Our ref: DOC20/30520

Subject: Walla Walla Solar Farm (SSD 9874) – Response to Submissions

ATTACHMENT A BCD advice for Walla Walla Solar Farm Submissions Report (SSD 9874)

Indicative Fence Flood Gate

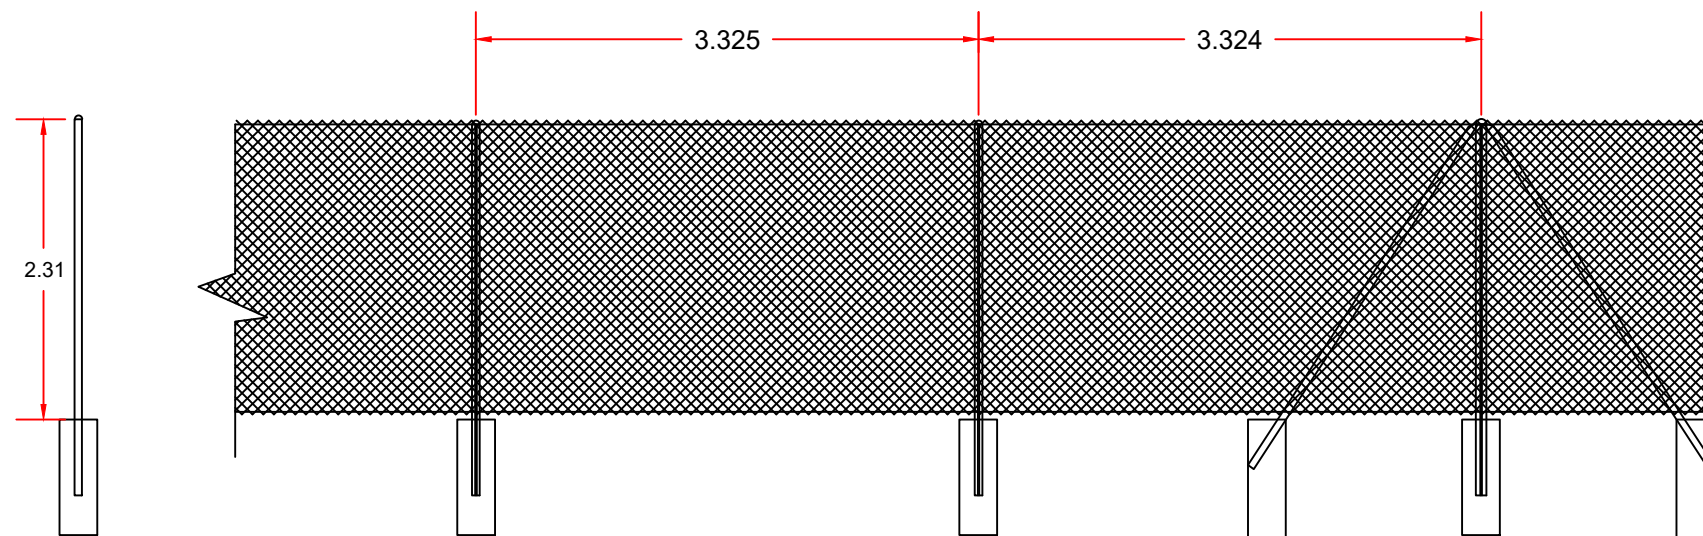
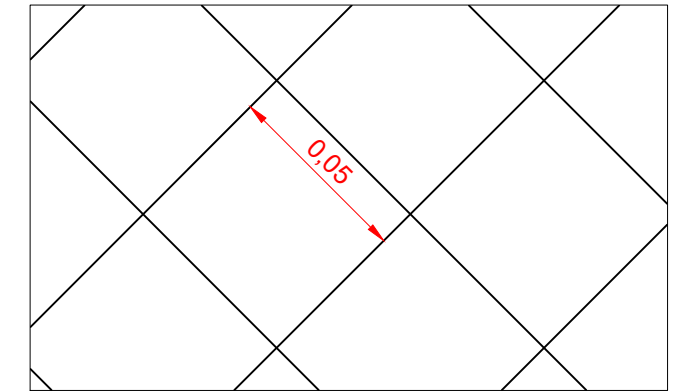
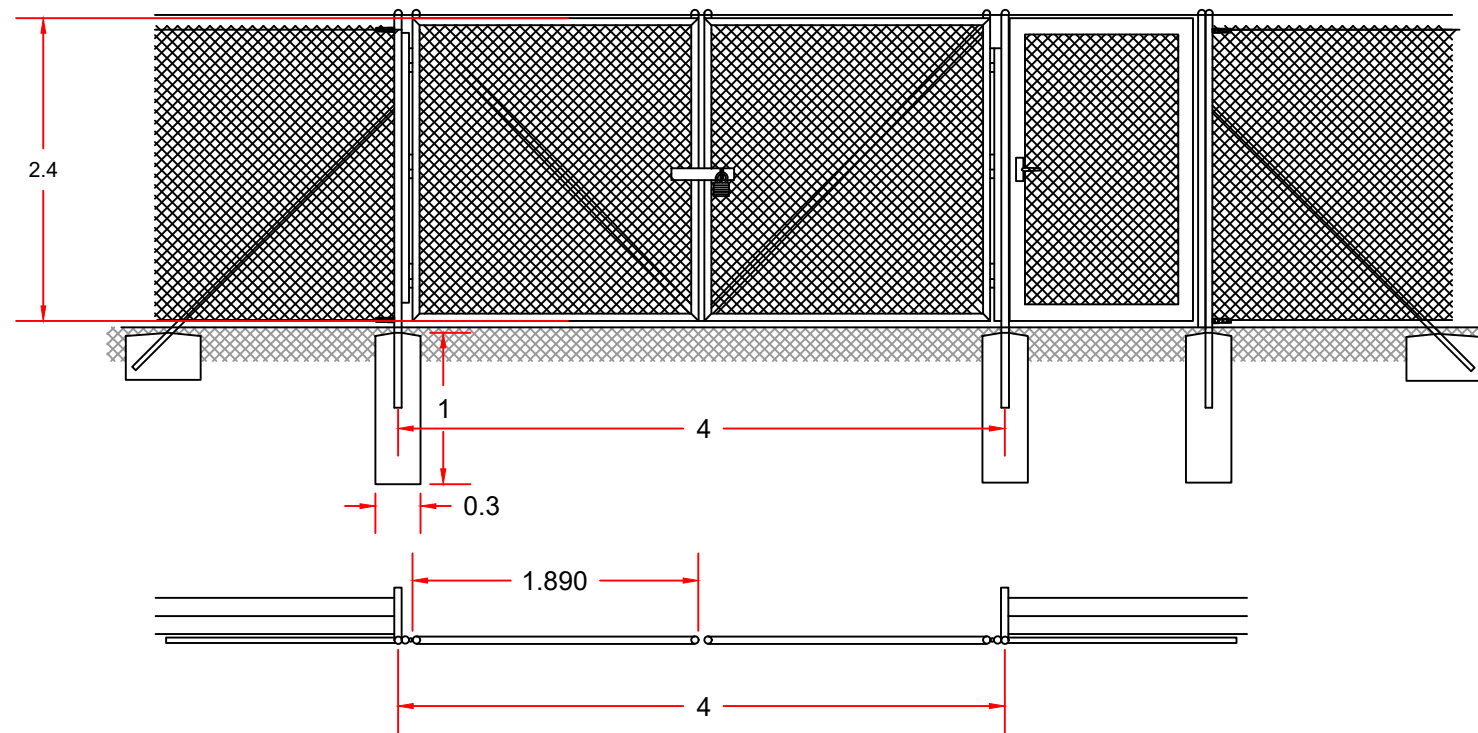
<p>One of these polygons is Zone 10, which has not been included in BAM-C. (Case 00013164/BAAS17109/20/00013165 Rev 2).</p> <ul style="list-style-type: none"> – BAM compliance requires assessment of impacts to biodiversity and threatened species habitat from all components of the development, including security fencing and the associated 10 m APZ. <p>The reference to direct impacts assessed by the BAM being consistent with clearing of native vegetation as defined in Part A, Section 60C, of the <i>Local Land Services Act 2013</i> is incorrect. Direct impacts are any direct harm to native vegetation.</p> <p><u>Please note</u> that advice from BAM support has been incorrectly interpreted – all vegetation zones in the development site should be entered into BAM-C. Assessment of biodiversity values over the entire site is necessary (as per Section 3.1.1.1 of the BAM) if other constraints require extra vegetation impacts in the future, the assessment has not been properly completed or accidental clearing or disturbance occurs outside the proposed development footprint.</p> <ul style="list-style-type: none"> • <i>Revise the future vegetation integrity score for Zone 4 to 0 and recalculate the credit requirement. Insufficient evidence is provided to justify the assertion that construction and operation of the solar farm has a lower impact on derived native grassland than other vegetation types, or to justify the degree of impact presented in the BDAR.</i> – The revised BDAR has not resolved the provision of two future vegetation integrity (VI) scores for Zone 4. <ul style="list-style-type: none"> ○ Table 10-1 (page 107) and BAM-C gives the future vegetation integrity score for Zone 4 as 3.6, which is 78% of the full impact if completely cleared. ○ Table 7-3 and the discussion in Section 7 (page 84) give a future VI of 14.1, which is 13% of the full impact if completely cleared. <p>The information supplied in the revised BDAR (Appendix J) has minimal information about impacts to native biodiversity and threatened species habitat. There is insufficient evidence with reference to scientific literature or monitoring programs to justify any modification to future VI scores.</p> <p>The offset requirement is to compensate for the loss of threatened species habitat for all the ecosystem credit species predicted to occur in PCT 76. A reasonable justification would address the impact of the panel array and its future management on <u>ecological functioning</u> of the native vegetation within Zone 4, and the consequent impact on threatened species habitat.</p> <p>S7.1.1 gives unsupported statements about likelihood of recovery of grasses and forbs within PCT 76.</p> <p>Section 7.1.1 also states that Zone 4 has previously been ploughed, which does not match the assessment of Category 1-exempt land in the BDAR Appendix A</p> <p>We reiterate that impacts should include, at least consideration of shading and species diversity, concentration of rainfall and rain shadows beneath the panels, soil erosion potential in storm events,</p>
